OEH comment in letter dated 28 February, 2019	GHD response	EES response Nov 2019	GHD final response – Amended BDAR
<p>The site is not identified as a future business hub within the Western Sydney Parklands SEPP, and as such, the proposal is inconsistent with the vision for the parklands.</p>	<p>AE Design have advised this item is no longer relevant as the application is no longer for a 'Business Hub', rather for 'Tourism purposes with associated facilities'.</p> <p>GHD noted the site falls within Precinct 11 (Cecil Park North) of the Western Sydney Parklands Plan of Management 2030 (adopted in December 2018). This updated Plan of Management notes that precinct 11 is <i>"isolated from the main parklands corridor by the M7 Motorway, the future M12 motorway and Elizabeth Drive"</i>. It also notes that the desired future character of the precinct is <i>"to provide for bushland and semi-rural paddocks as interim land uses, with future investigation into potential business or tourism uses. Allowance will be made for the future M12 Motorway corridor and associated infrastructure, if required"</i>.</p> <p>The Wallgrove Road Business Hub is noted to be under investigation about 480 metres t

**Photo 1 Large artificial waterbody in the north of the study area, showing lack of emergent vegetation**

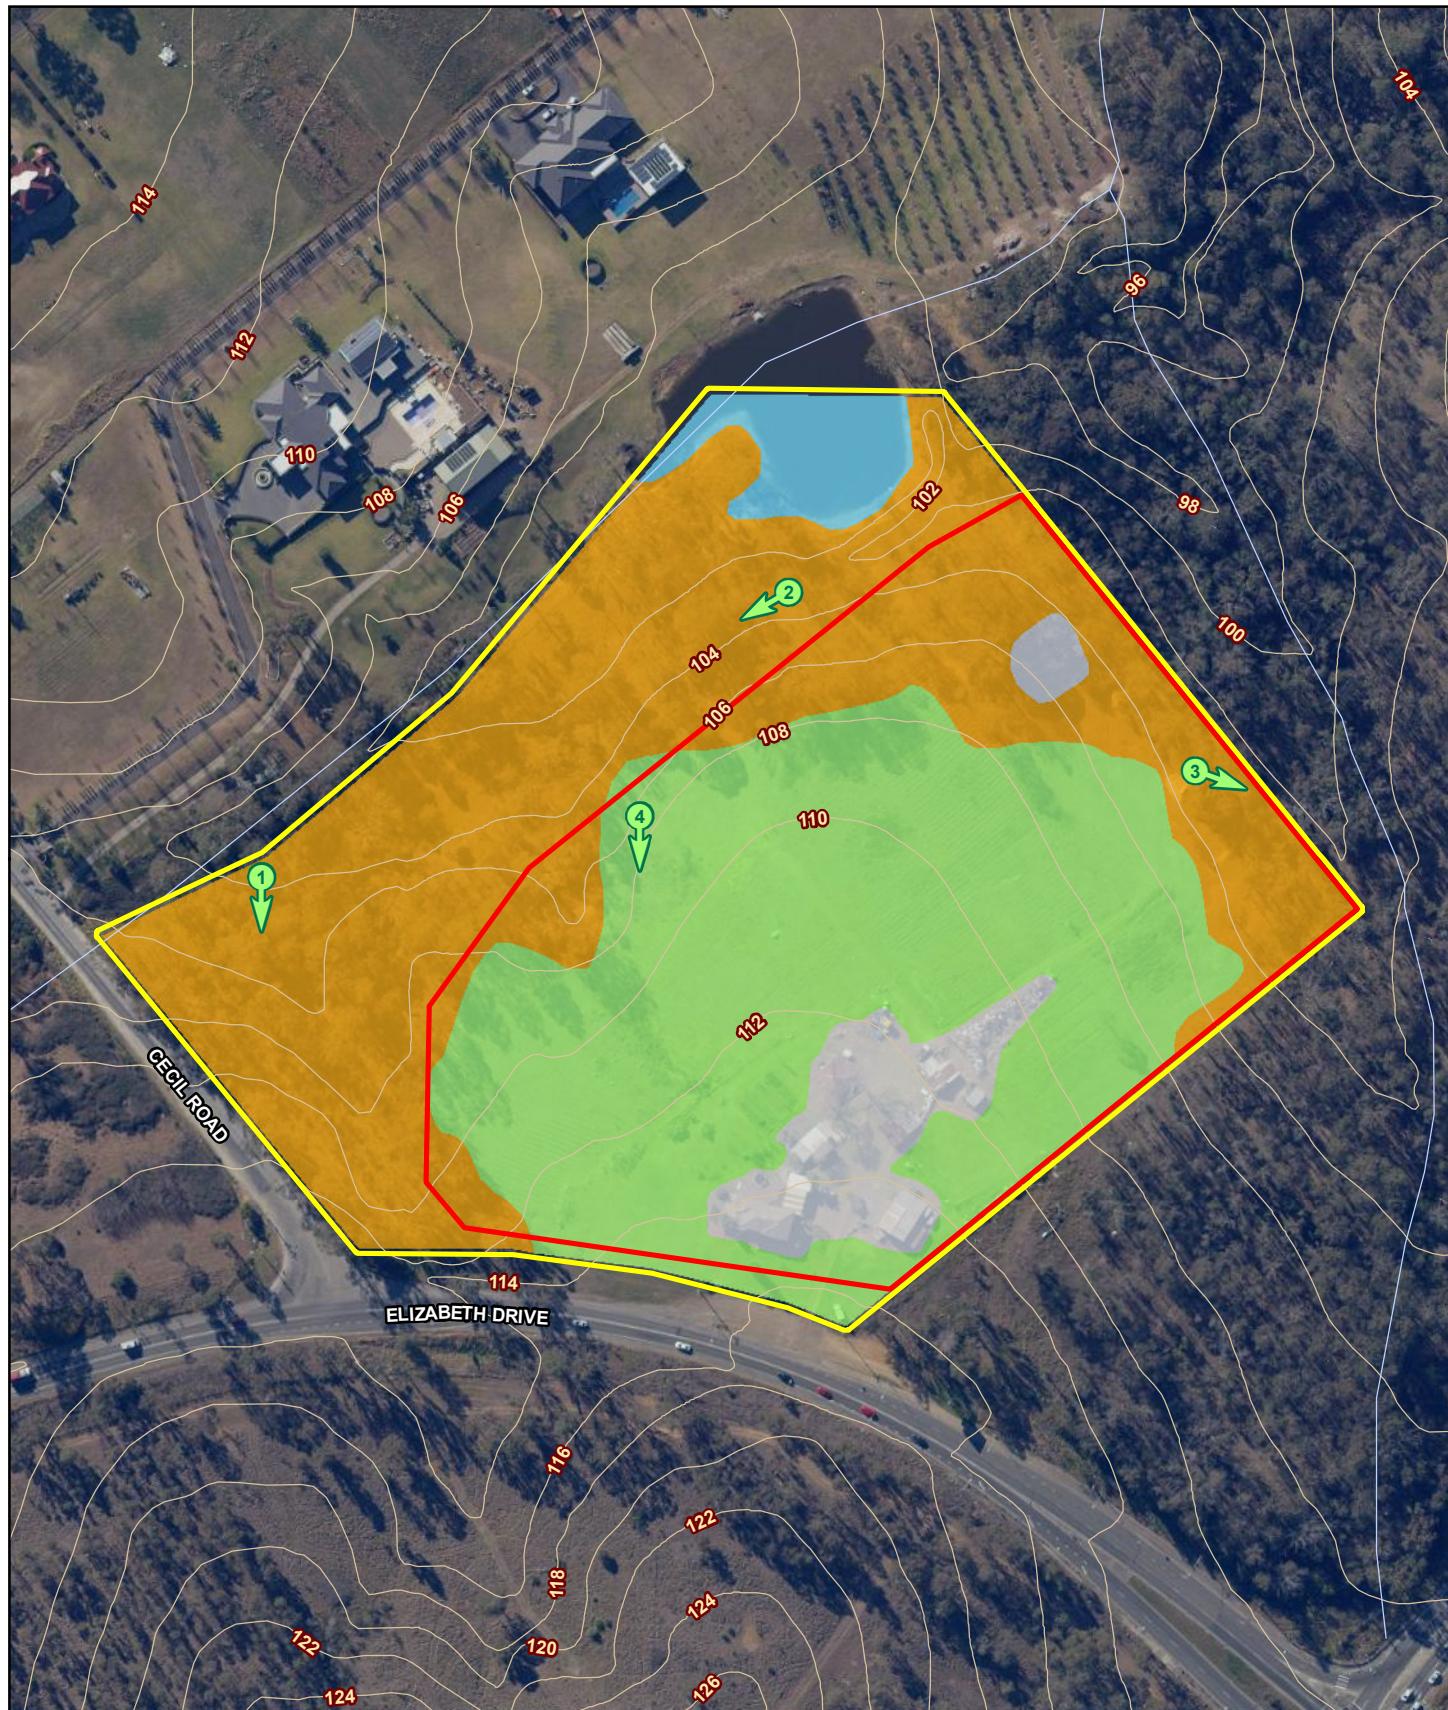
<p>Potential impacts on aquatic fauna have not been adequately addressed. The BDAR states that there is no permanent aquatic habitat occurring within the subject site.</p>	<p>The BDAR states:</p> <p><i>“No permanent aquatic habitat occurs within the subject site. There is a small ephemeral drainage depression that runs through a small section of the subject site in the west. The nature and condition of this drainage line was not assessed for fauna habitat values, given the absence of water and the small area which it occupies in the subject site.”</i></p> <p>GHD will update this paragraph to better portray aquatic habitat present on site.</p> <p>Updates to include:</p>	<p>All direct and indirect impacts on the dam and associated creek line, which lie to the north and north west of the site, need to be addressed in the BDAR as per section 9 of the BAM. Note that even if direct impacts will not occur in these areas, indirect impacts will need to be assessed as the dam and creek line are adjacent to the proposed development (see section 9.1.1.2 of the BAM).</p>	<p>N/A – The area referred to in EES response is now the subject of acquisition by TfNSW for the M12 project. Impacts associated with this area would be addressed via the M12 approvals process.</p>

<p>Permanent aquatic habitat within the study area is limited to constructed farm dams, with water levels that vary depending on the amount of rainfall received. There is a small ephemeral drainage line (dam inflow) that leads to the large dam within the study area, to the north of the subject site. This lacked flowing water at the time of all field surveys, with only small, shallow pools present, and as such, it was not surveyed for aquatic habitat.</p> <p>The large dam and associated ephemeral inflow drainage line are not within the proposed subject site. They sit within the proposed vegetation reserve in the north of the site and are not proposed for removal.</p>		
<p>The BDAR states that the “larger artificial water body in the north west of the study area lacks any fringing, emergent or aquatic vegetation and as such, is unlikely to provide suitable habitat for wetland species such as the Australasian Bittern or the Green and Golden Bell Frog”. However, aerial photos and the photograph of the front page of the stormwater report show fringing vegetation near the dam.</p>	<p>Photographs taken on site during field surveys demonstrate the lack of fringing, emergent or aquatic vegetation within the subject site.</p> <p>[photo]</p> <p>The preferred habitat of the Green and Golden Bell Frog “always contain plenty of vegetation in and around water” (<i>Best practice guidelines Green and golden bell frog habitat</i>; DECC 2008). Further, they are known to prefer sites that support <i>Typha</i> spp. or <i>Eleocharis</i> spp. which are unshaded and have a grassy area and/or rubble as shelter/refuge habitat nearby. The assessment contained within the BDAR that no suitable habitat for the</p>	<p>Noted.</p>	<p>N/A – The area referred to in EES response is now the subject of acquisition by TfNSW for the M12 project. Impacts associated with this area would be addressed via the M12 approvals process.</p>

<p>Green and Golden Bell Frog is considered accurate and appropriate, given the conditions present on site. There is no vegetation in the water, limited vegetation around the water (limited to exotic grasses such as Kikuyu and patchy native grasses or canopy trees with no understorey species and bare earth), and no occurrences of <i>Typha</i> spp. or <i>Eleocharis</i> spp.</p> <p>The Australasian Bittern favours permanent freshwater wetlands with tall dense reedbeds, particularly <i>Typha</i> spp. and <i>Eleocharis</i> spp. With adjacent shallow, open water for foraging. Roosts during the day amongst dense reeds of rushes. Feeding platforms may be constructed over deeper water from reeds trampled by the bird; platforms are often littered with prey remains. The photos taken on site confirm that there is no suitable habitat present for this species on site (see below and above).</p> <p>Further, a review of aerial photographs of the subject site do not show fringing, emergent or aquatic vegetation around the dam in the subject site.</p> <p>Notwithstanding, the farm dam and associated ephemeral drainage line in the north of the site is within the proposed vegetation reserve, and is proposed for retention.</p> <p>[photo]</p>

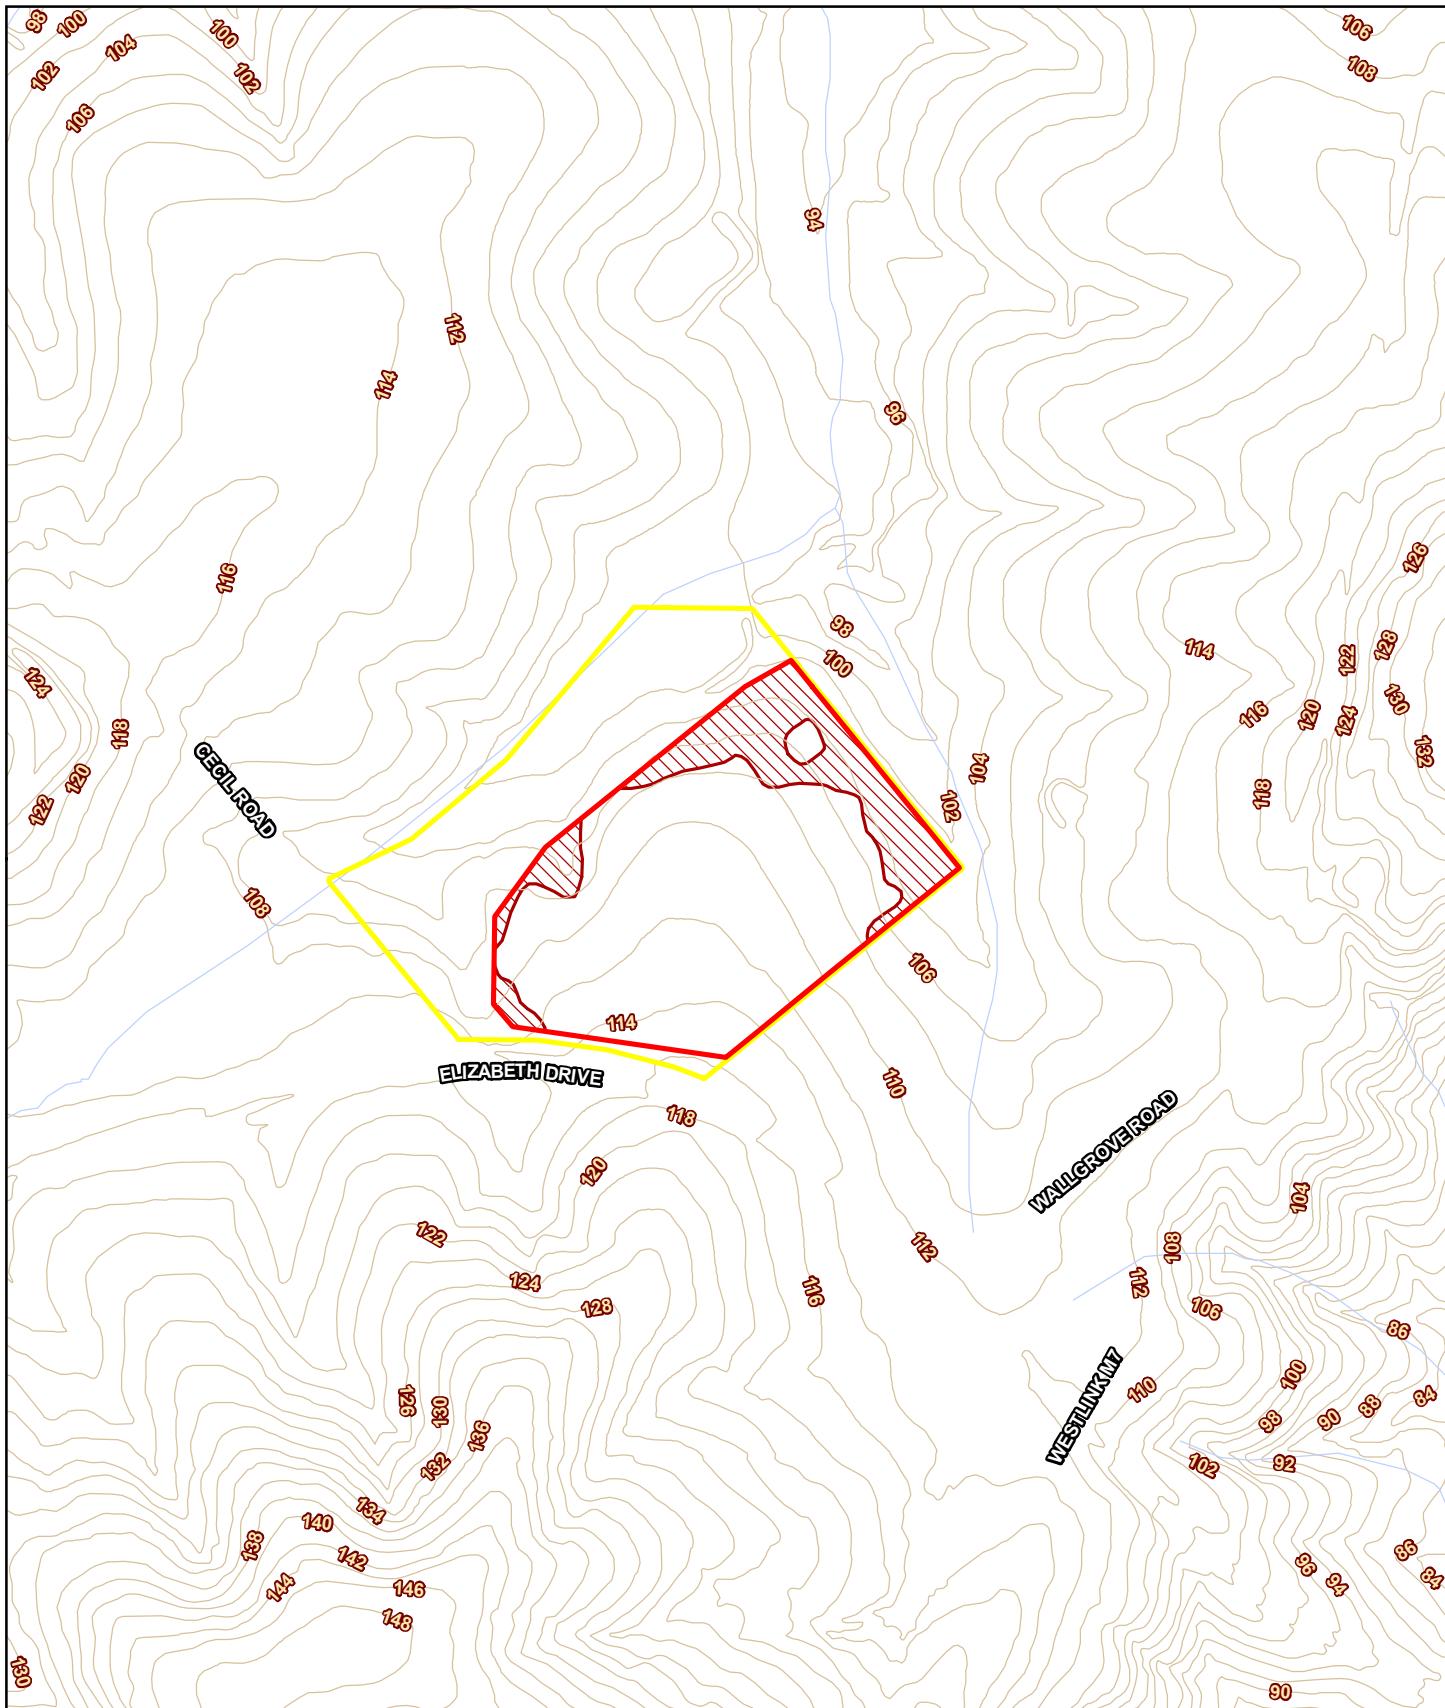
<p>The method used to calculate the species polygon for the Southern Myotis (Chapter 6.6 of the BDAR) grossly under mapped the habitat components for this species. No mapped drainage lines, on or adjacent to the site were used to map the polygon because they were not considered to be foraging habitat.</p> <p>The method used to develop a species polygon for the Southern Myotis must be as per S. 6.4.1.33 of the BAM, Table 1 of ‘<i>Species credit’ threatened bats and their habitats: NSW survey guide for the BAM</i> (OEH 2018) and from information contained within the TBDC:</p>	<p>GHD acknowledges that OEH’s comments on calculation of the species polygon for the Southern Myotis are correct, with reference to the new BAM bat survey guidelines, which were published in September 2018.</p> <p>Prior to the publication of the 2018 BAM microbat survey guidelines, the Southern Myotis was assumed to be present at the site, and a species polygon was mapped in early 2018. The approach used to generate the species polygon (i.e. a 100m buffer around permanent riparian habitat) had been accepted by OEH on previous BioBanking assessments on numerous occasions. GHD recognised that this should be increased to a 200m buffer in the updated BDAR to ensure consistency with the new guidelines. Drainage lines within the study area and subject site do not comprise habitat for the Southern</p>	<p>The method used to calculate the species polygon for Southern Myotis must follow:</p> <ul style="list-style-type: none"> <li>• section 6.4.1.33 of the BAM</li> <li>• Table 1 of ‘<i>Species credit’ threatened bats and their habitats: NSW survey guide for the Biodiversity Assessment Method</i> (OEH 2018) and</li> <li>• the Threatened Biodiversity Data Collection.</li> </ul> <p>Note that these references do not refer to permanent water.</p>	<p><b>Section 6.6 described the methods used to calculate the species polygons used in the credit calculations. Polygon shown on Figure 6.2.</b></p>
